EPPING PARK: STAGE 2 – BUILDING 17

ACCESS REVIEW

Morris-Goding Accessibility Consulting

20th June 2011

1 SITE PLAN
1 : 200

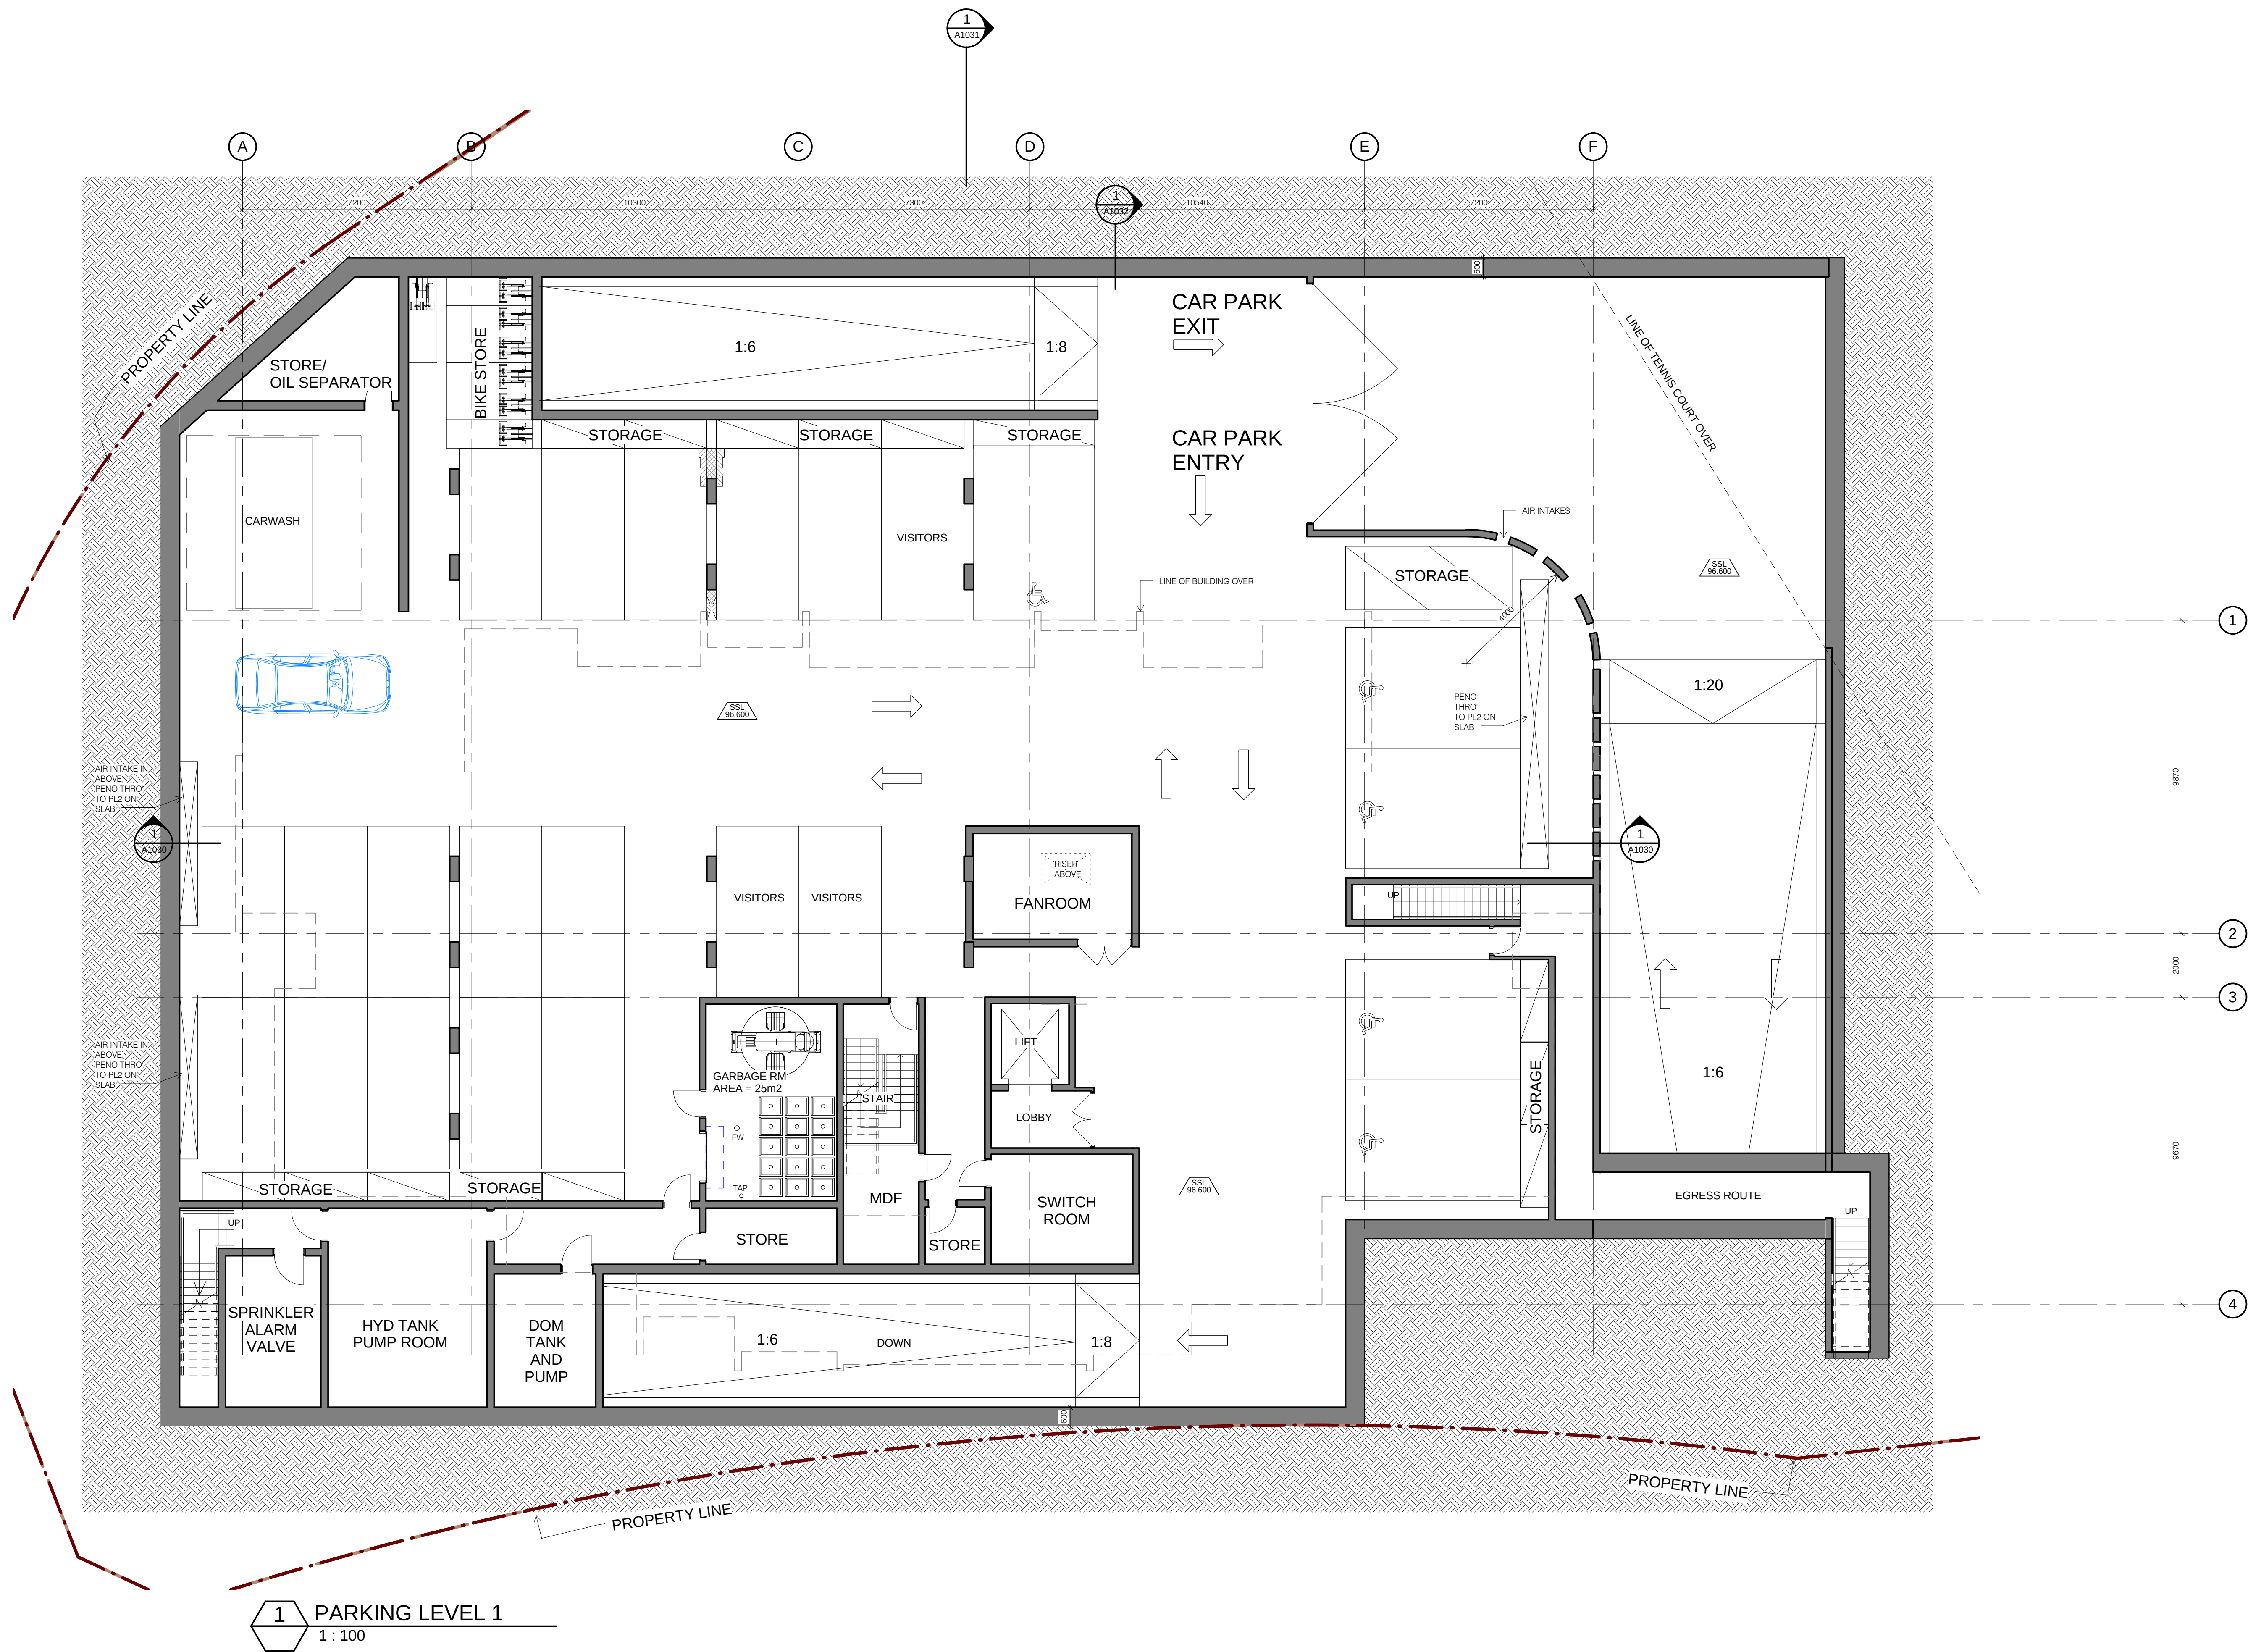
A total of 4 adaptable unit car bays have been provided on Parking Level 1 of the development. The car bays have a clear width of 3.8m compliant with AS4299.

- (i) All accessible car bays require a height clearance of 2.5 metres and 2.2m vertical clearance upon approach to each car bay.

1 GROUND FLOOR PLAN
1:100

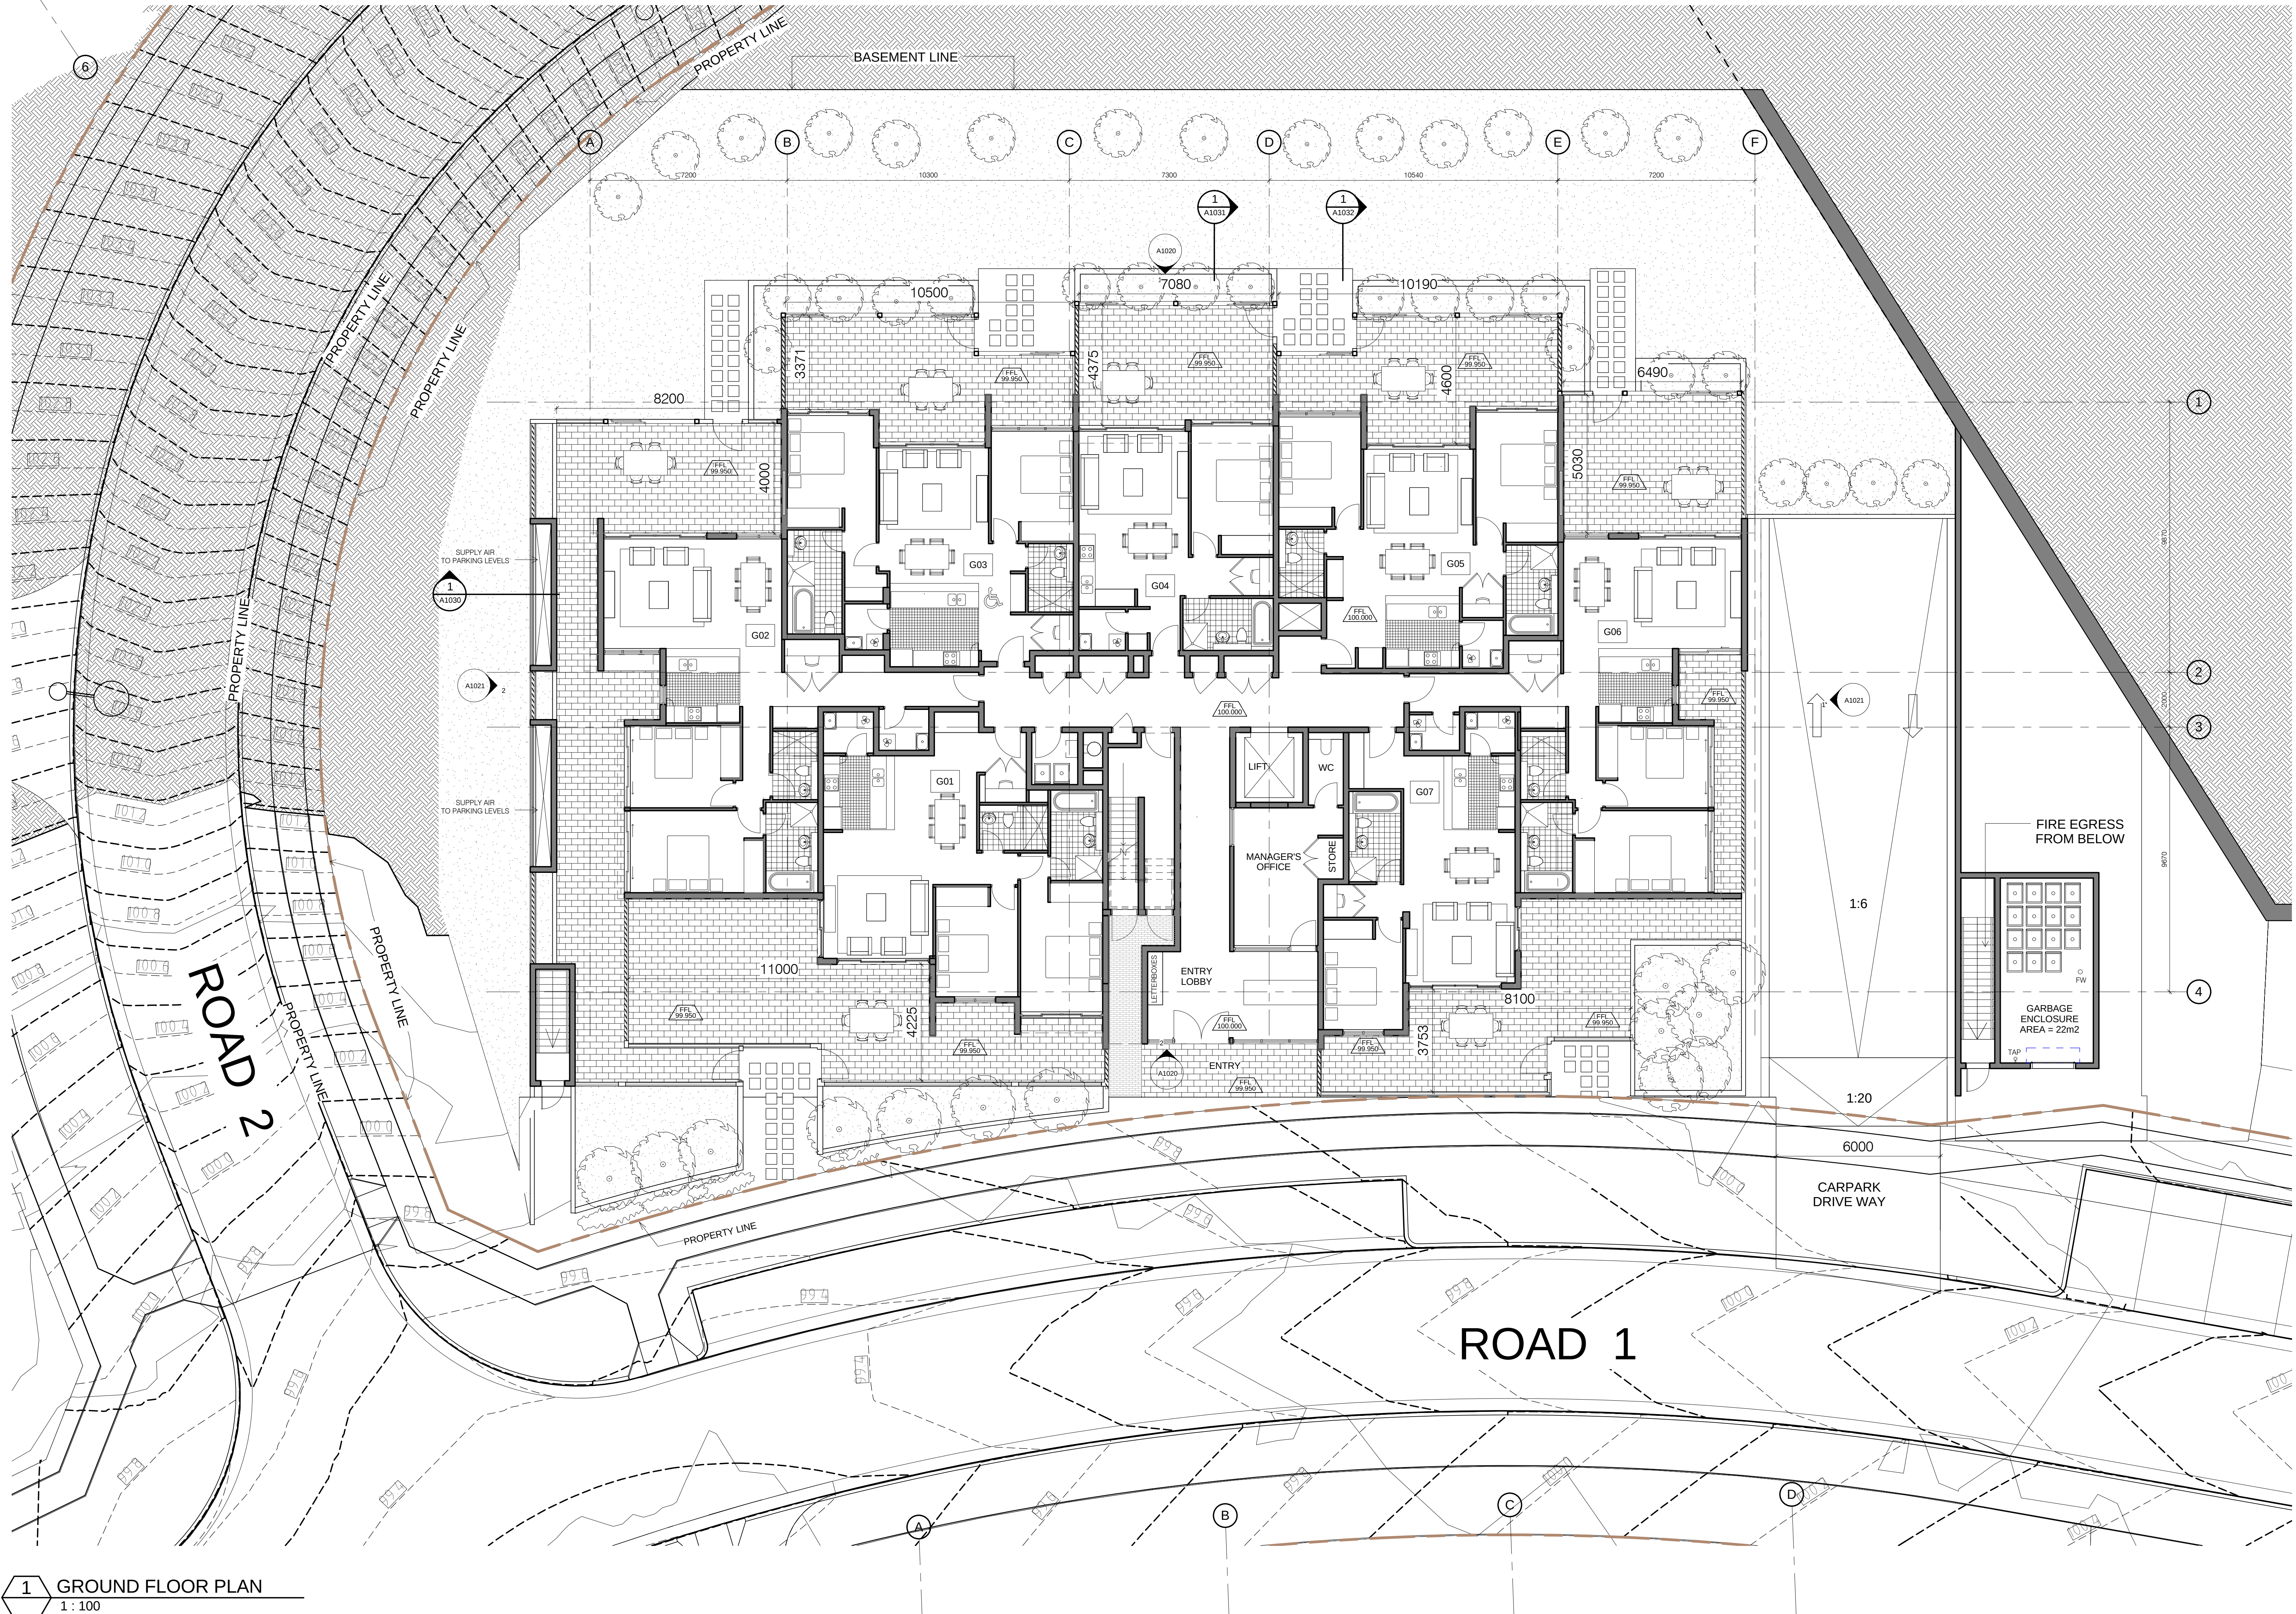
The main bedroom has a 785mm clear width door compliant with AS4299. The door has a 1200mm depth clearance which will need to be enlarged to ensure wheelchair side approach compliant with AS1428.1:2009. The bedroom has internal dimensions of 3215mm x 4135mm outside the robe area

The accessible ensuite is accessible via a 1025mm entryway and a 710mm clear width door. The door has a 335mm external latch side clearance. The toilet has internal dimension of 1920mm x 3170mm which will need to be enlarged to ensure an appropriate circulation area around the pan, basin and shower recess.

The laundry is accessible via a pair of sliding doors with a 1010mm clear width with a 240mm latch side clearance. There is an 1220mm clearance within the laundry non-compliant with AS4299.

- (i) Ensure a 1240mm clearance at the internal leaf of the bedroom door suitable for wheelchair side approach compliant with AS1428.1:2009, fig. 31.
- (ii) The main bedroom requires minimum internal dimensions of 3.6m x 3.6m suitable for wheelchair manoeuvrability.
- (iii) Ensure the accessible ensuite has a 1240mm clear depth at the door which minimum 820mm clear width an 470mm latch side clearance compliant with AS4299.
- (iv) Bathroom (shower, toilet, wash basin) to comply with circulation area requirements of AS1428.1:2009, that is provide an area of 1900mm x 2300mm around the pan. The wash basin should sit outside this area, and if needed only encroach into this area by 100mm (max). The shower area requires 2500mm x 1600mm. An internal dimension of 2.3m x 2.7m will satisfy this requirement.

- (v) Laundry door to have a minimum 850mm clear width and 510mm latch side clearance on the internal leaf suitable in accordance with AS1428.1:2009.
- (vi) The laundry requires a minimum 1550mm turning circle in front of laundry appliances compliant with AS4299.
